Report following a request for further information, negotiations or consultation

REF NO:	Y/103/18/PL
LOCATION:	10 Acre Field North of Grevatts Lane Yapton
PROPOSAL:	Single Chapel Crematorium with car parking, landscape works, surface water drainage features & associated highway improvements. This application is a Departure from the Development Plan.

As a result, the Council instead requested that quotes for (1) RSA based on one normal visit and (2) a critique of the data and modelling in the applicants Transport Assessment to check that it is robust enough. A preferred contractor was chosen, Wilbar Associates Ltd, and their reports were received on Friday 20th September.

PBA drawing 128.001.007 Rev D

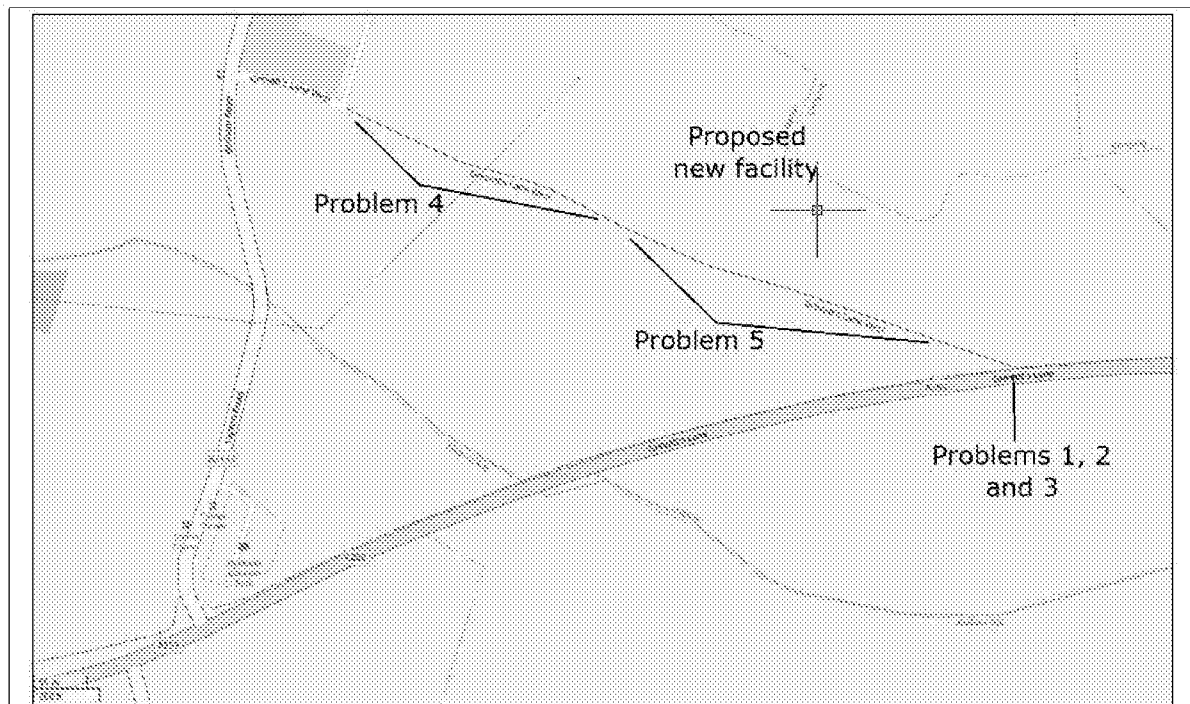
Summary: On the preliminary design layout the tactile paving appears to be offset from the substantive through route of the shared path. Pedestrians, particularly those who are blind or partially sighted may therefore continue their established direction and 'miss' the tactile paving and continue across the junction with the risk of collision with turning vehicles.

Recommendation: Discuss with West Sussex County Council (Highway Authority) and provide additional details on the facilities for pedestrians. Consider the realignment of the existing shared use path at a point further back from the proposed junction.

Summary: Whilst most visitors to the new facility will no doubt arrive by motor car the Transport Statement recognises that some visitors will arrive by other means. It is unclear from the preliminary design if a footway is to be provided as part of the improvement from the A259. If not, then pedestrians who choose to access the new facilities from the A259 will be required to use the 400m carriageway with risk of collision with vehicles.

Recommendation: Review the design of the track improvement and the provision of facilities for pedestrians.

(a) The additional signage and tactile paving will be secured through the s278 agreement and the Stage 2 RSA. The client is happy to commit to the signage and tactile paving;

(c) The provision of a footway along Grevatts Lane West would not be proportionate to the impact of proposal given that the existing highway provides a very low trafficked safe shared route; and
